Subject: RE: Attached letter from Kirklees Council regarding application number 2025/90820 at location The Stables adj, 84, Woodhead Road, Holmbridge, Holmfirth, HD9 2NL

Bridges & Structures Manager
Structures Section
Highways and Streetscene
Kirklees Council

General Arrangement as Proposed

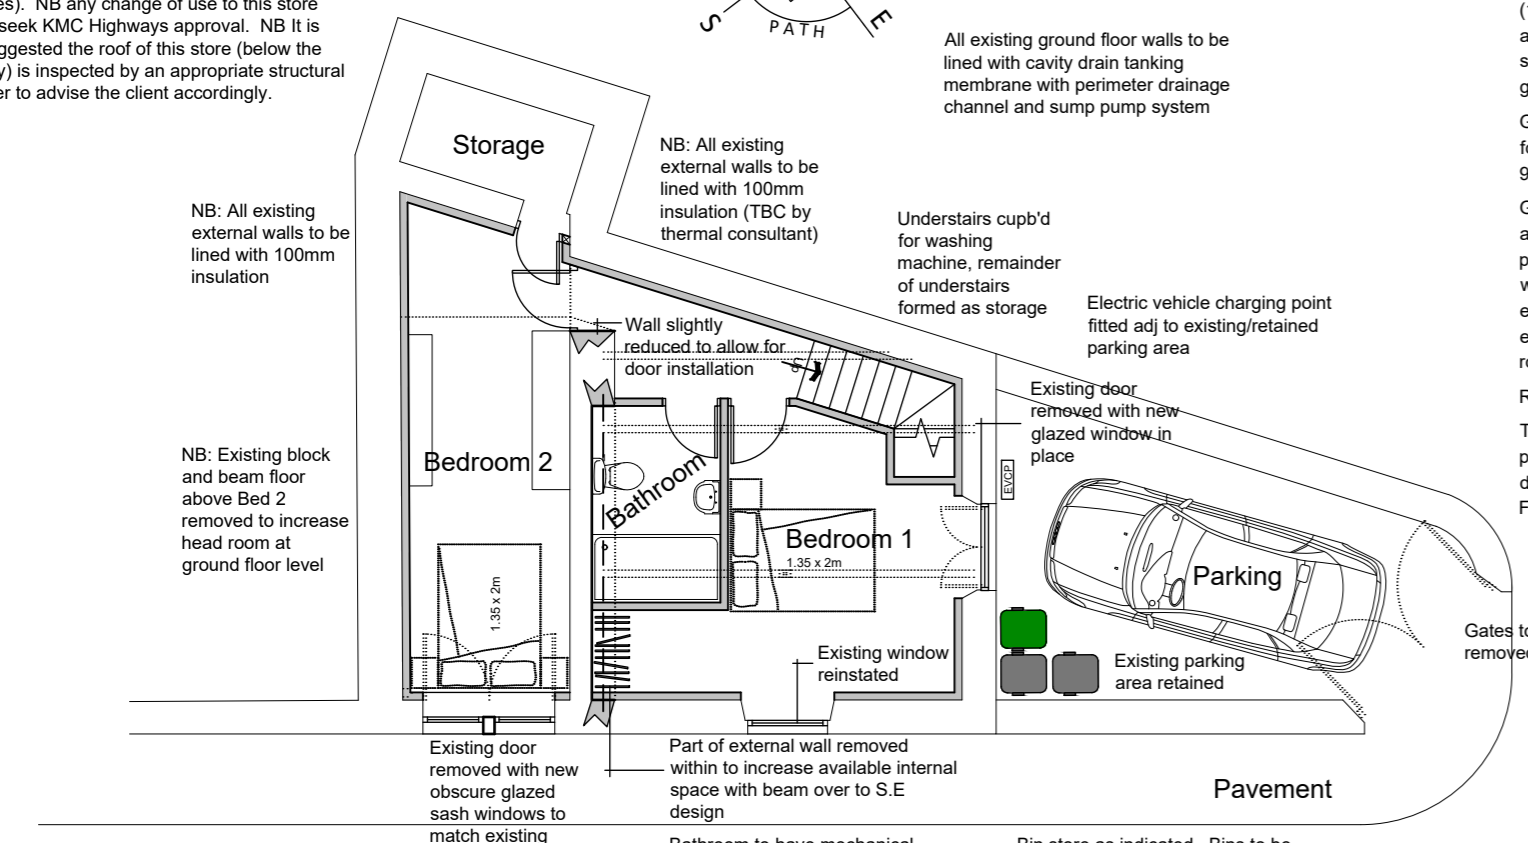
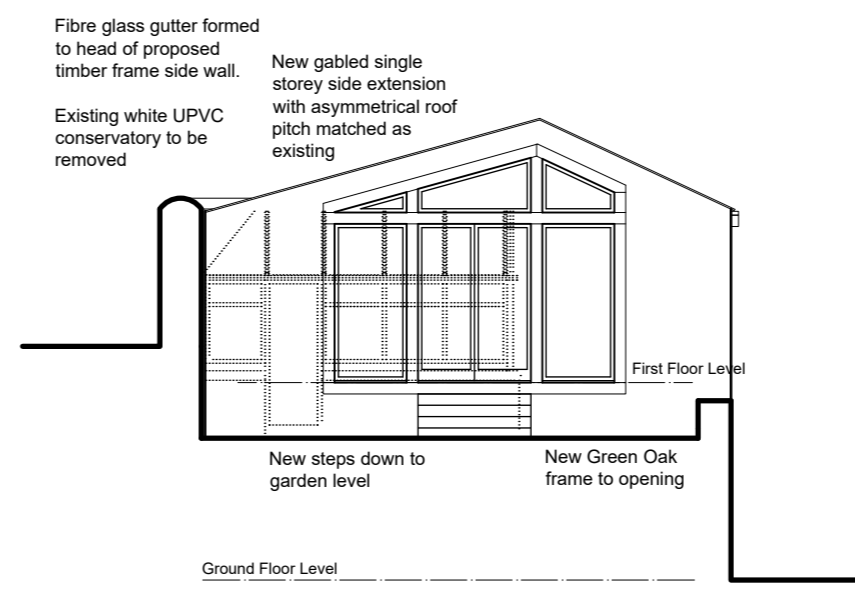
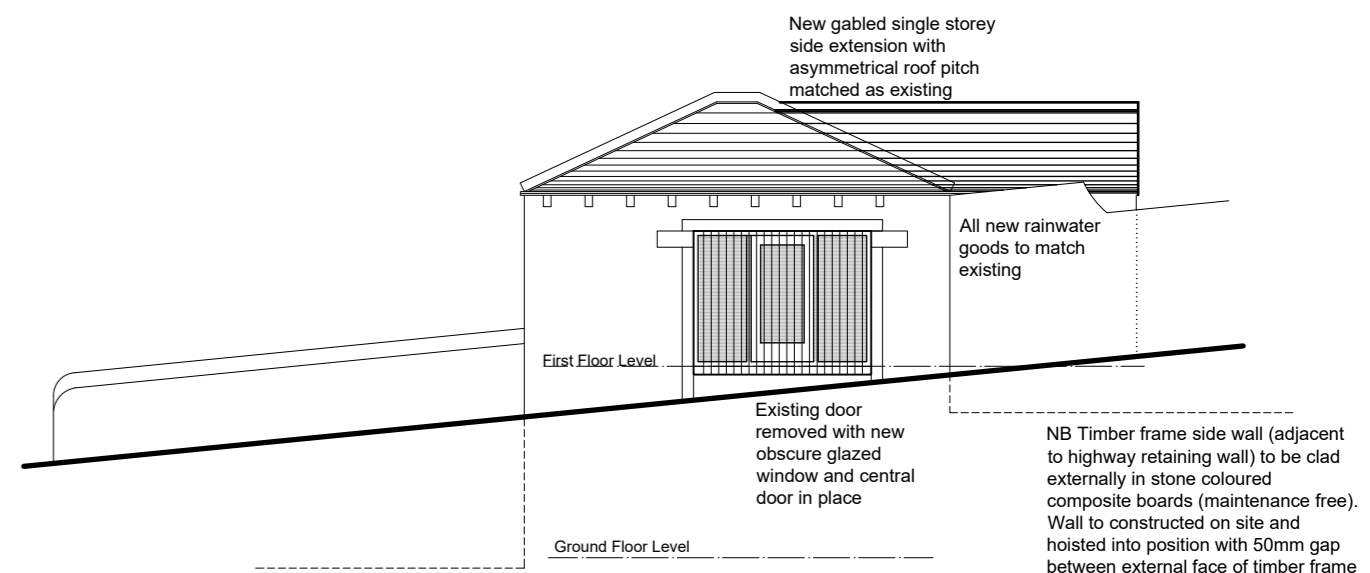
Please also advise the agent that the existing boundary retaining wall and the coal storage space projecting beyond the property and beneath the highway are private structures and as such maintainable by the adjoining building proprietor.

Drawing Title
Highway Sections

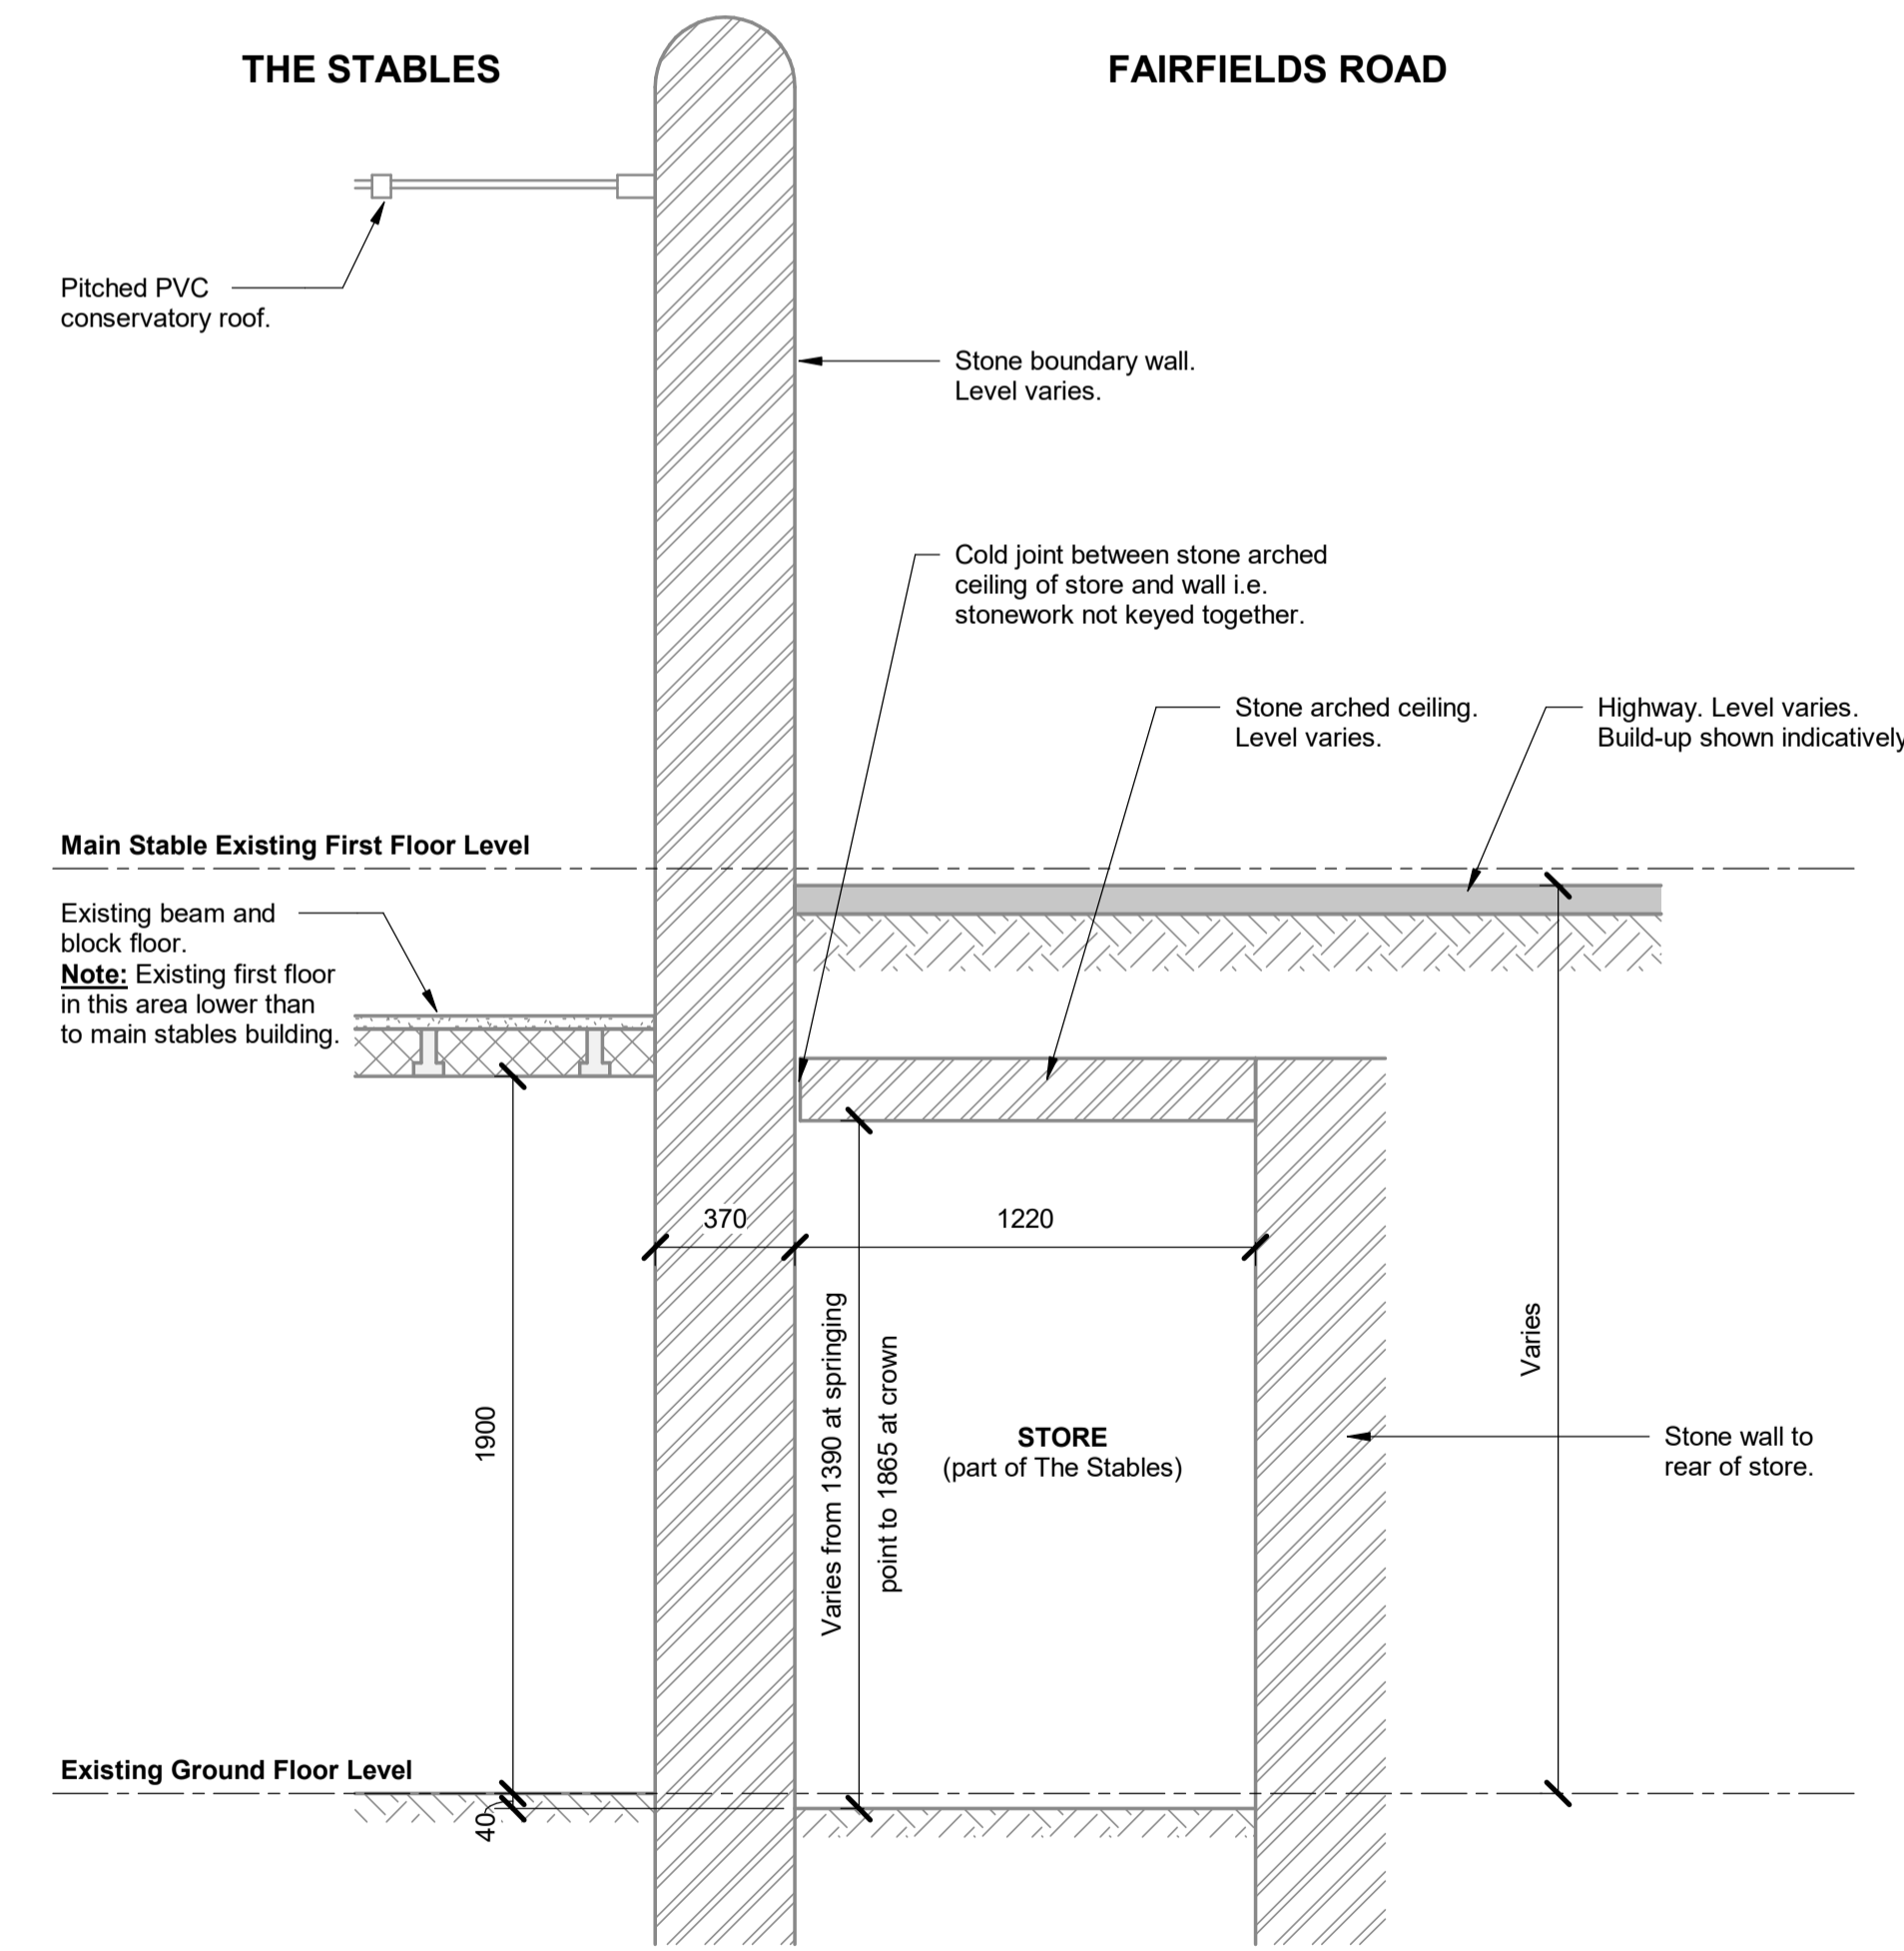
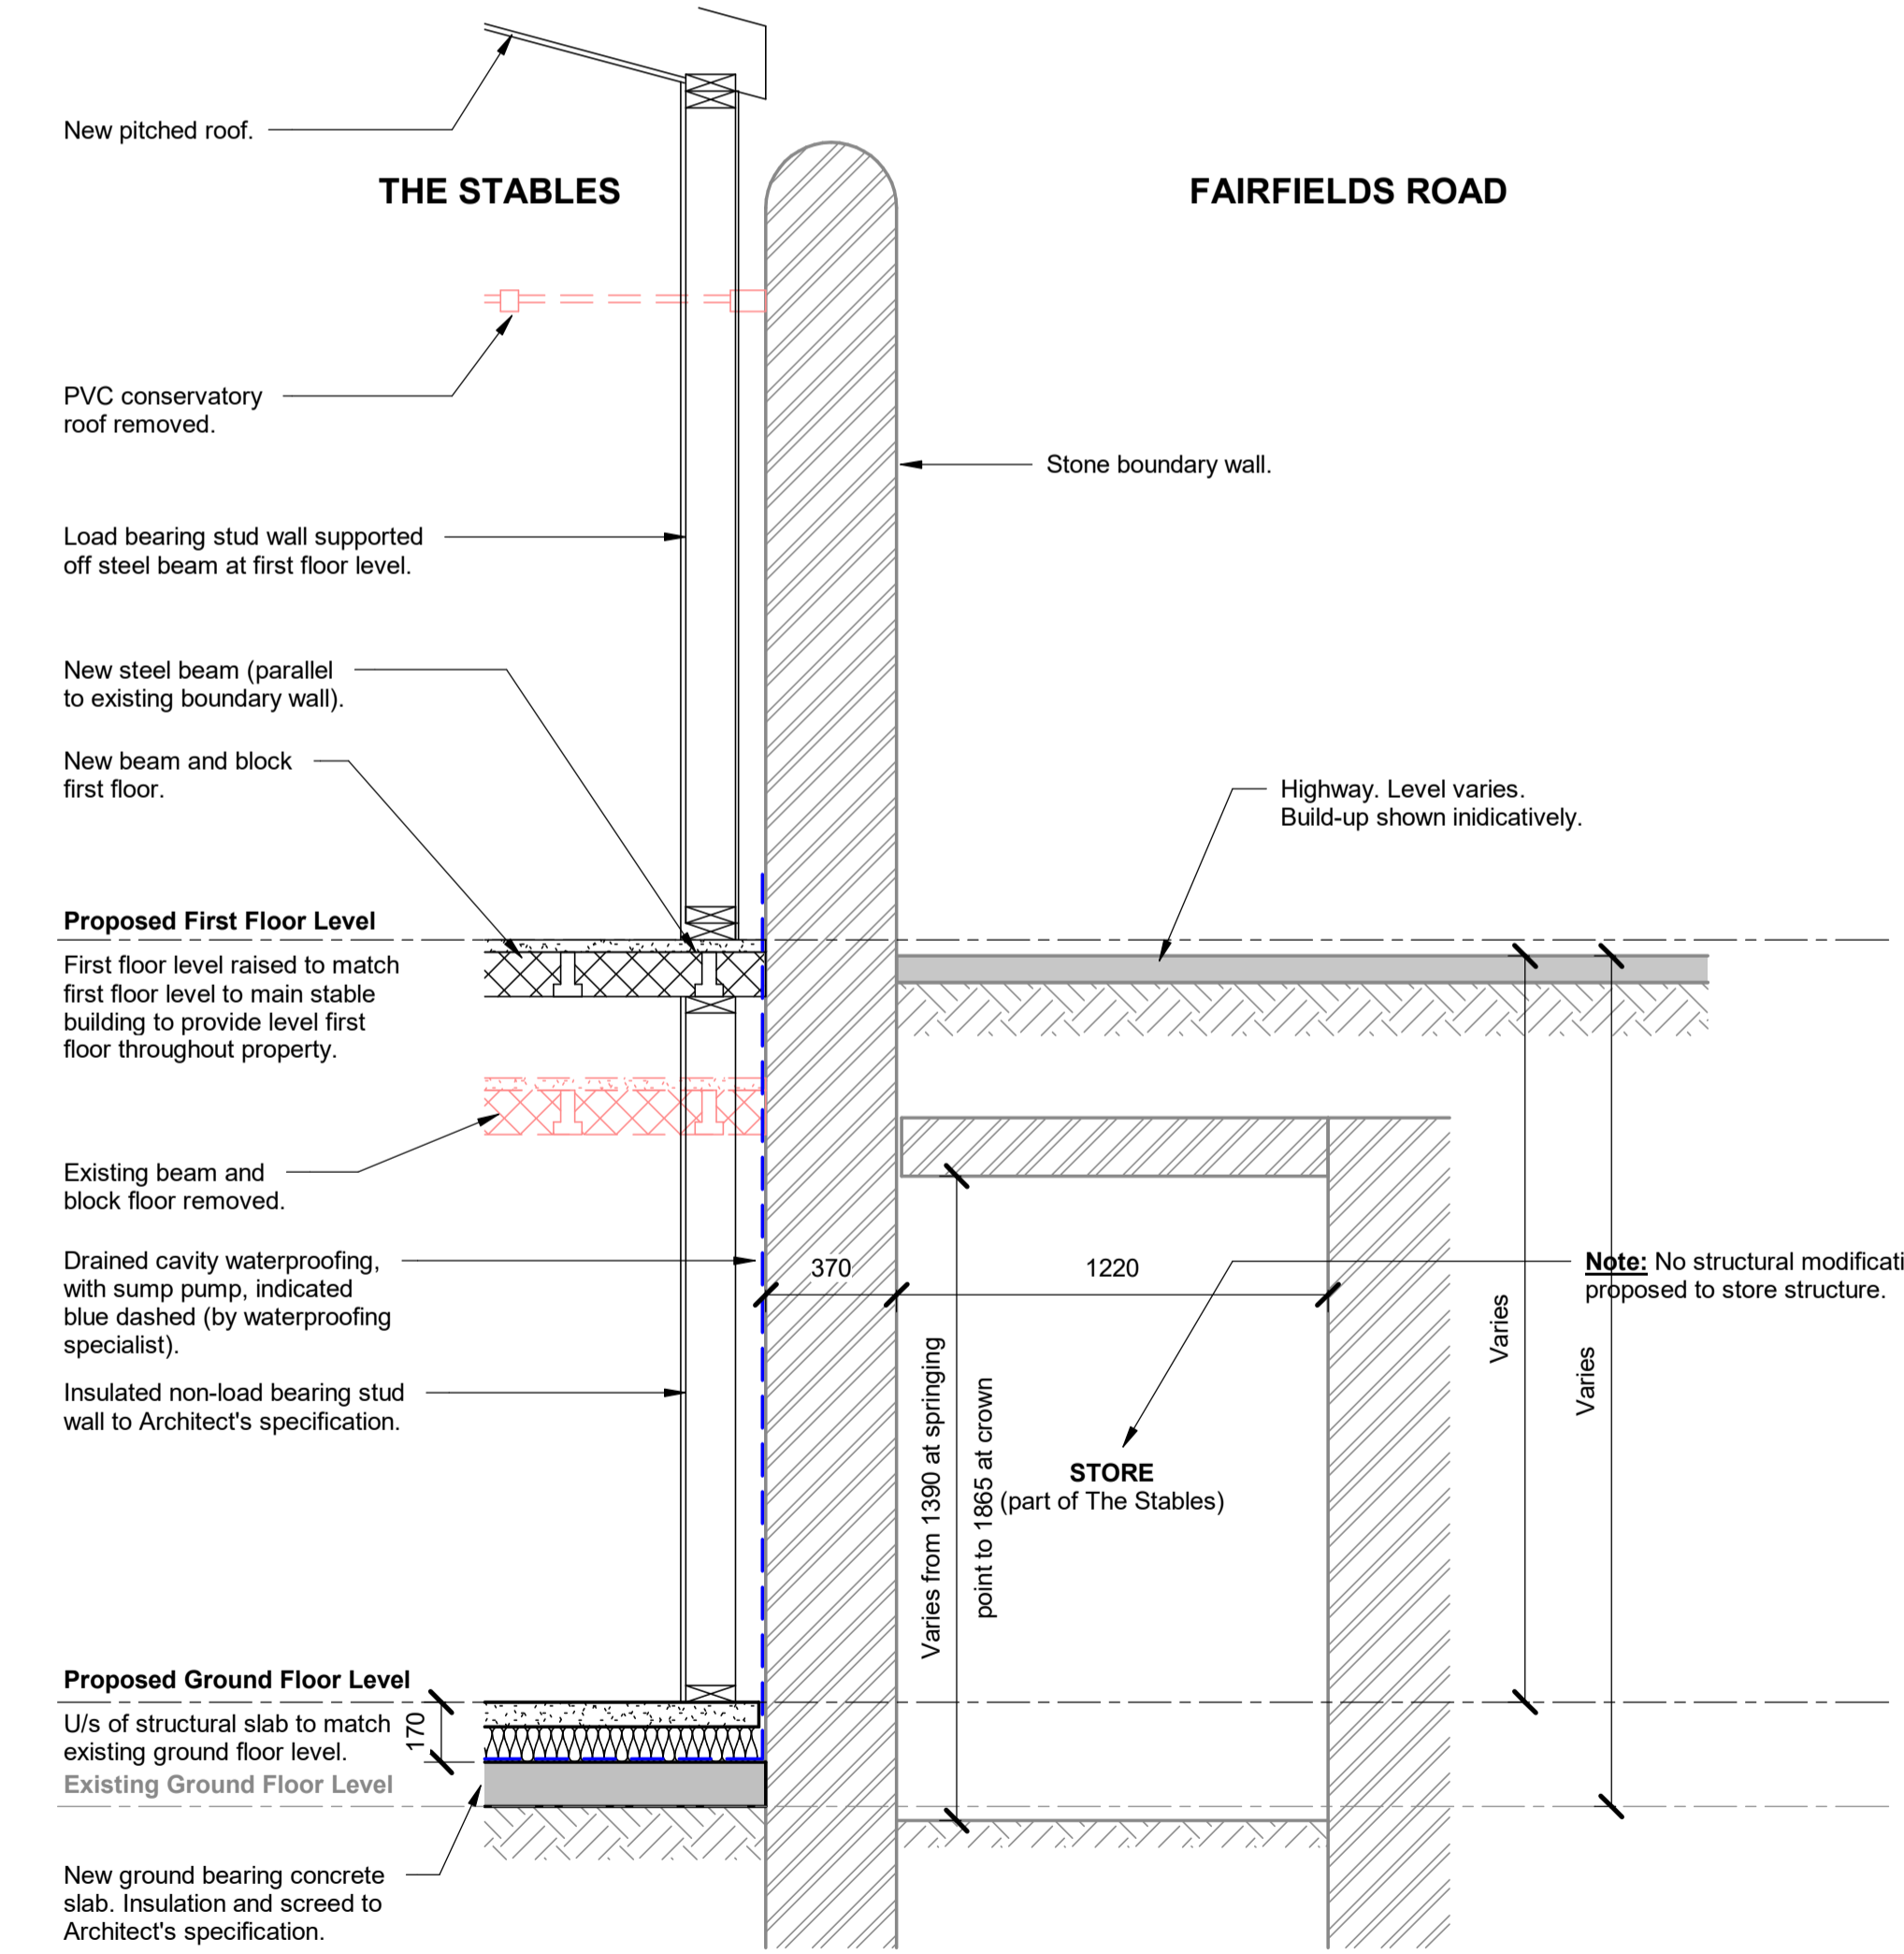
Further to the commentary provided by the agent, I would like to stress that the highway structures condition was imposed based on the information submitted with their application. This is a standard Structure's condition that is imposed where the proposals are likely to undermine the adjoining highway and thereby impact the safety of highway and its users, so it is not clear why the agent considers it to be restrictive. If they wish to amend their proposals, we will review their revised proposals and comment accordingly. In view of this, the advised condition will remain pending the submission of further details which would mitigate the need for the imposition of this condition.
